415 Cumberland Avenue

415 Cumberland Avenue - Final Traffic Comments

Subject: Application ID: 2018-011

PEZ 2018-011: Building Conversion, 415 Cumberland Avenue

1 | CUMBERLAND AVENUE ELEVATION
1/8" = 1'-0"

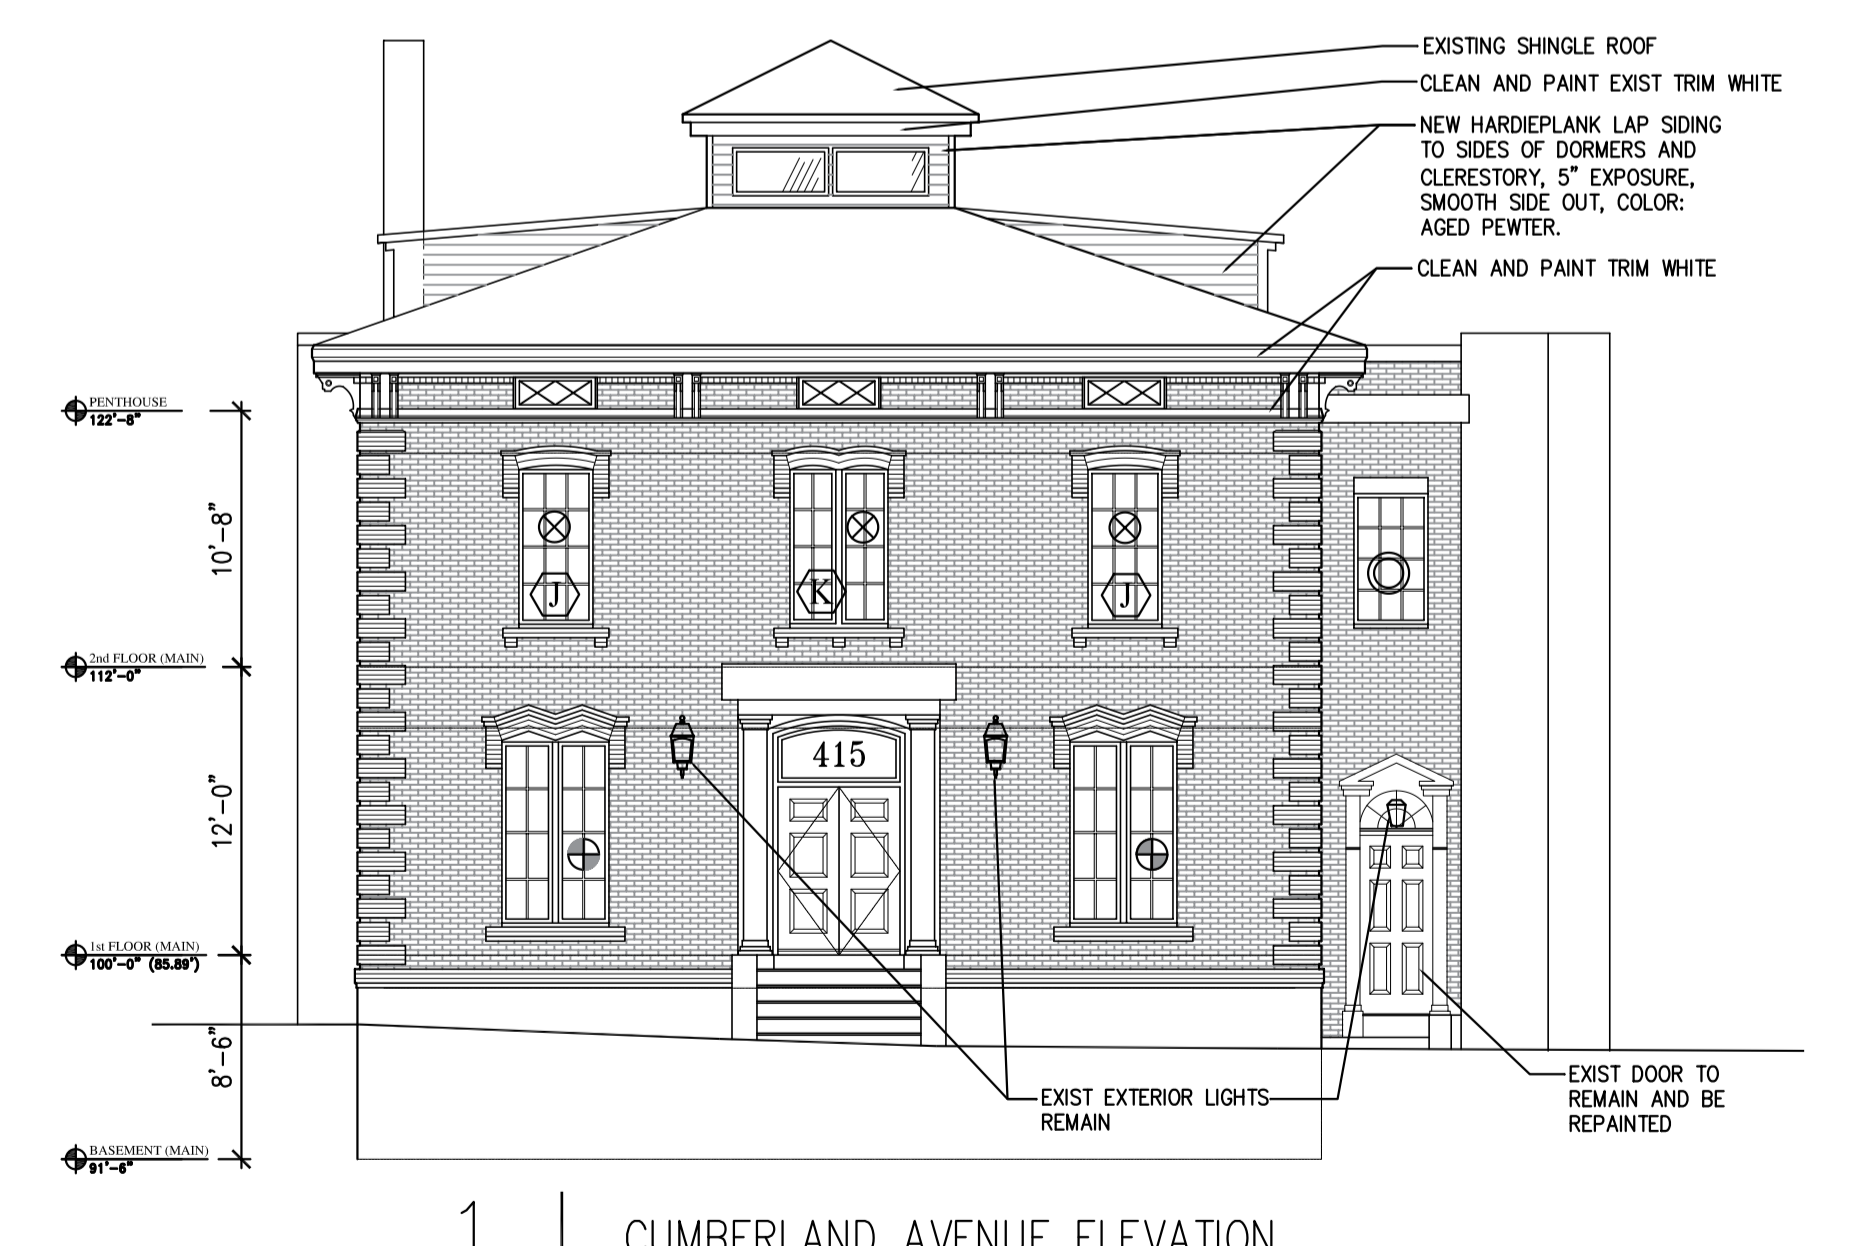
Request details on new windows. What are the materials? Windows should feature simulated divided lites with applied exterior muntins, at a minimum. Also, which windows will be repaired/replaced?

Request details regarding window moldings: will brick moldings be replicated in aluminum trim on other, new windows?

Why are two windows on the northwest elevation not the same height as all other windows on the northwest elevation and Forest Avenue elevation? Ideally these will match.

Request clarity / detail regarding the penthouse / mezzanine. What changes are being made, if any, and what materials are being used. Are the proportions of the existing windows changing?

Request details regarding finishes. Painted finish of Hardie plank should not be high contrast, nor should relationship of trim to body of building be high contrast.

What is reveal / ttw of Hardie plank? (Reveal should be less than 6.”)

Hardie plank should be installed smooth side out (please note on plans).

Exhaust vents should be painted to match surrounding material (brick or Hardie plank siding).

Hardie plank at top of building parapets on Forest Avenue and southwest elevations seem strange – the treatments / bands along the top of the building’s middle section should be continued.

Will garage doors be replaced? If so, materials / details requested.

Request details regarding proposed new door on Forest Avenue, especially regarding material and panelization.

Coal chute should be retained, not removed or covered.
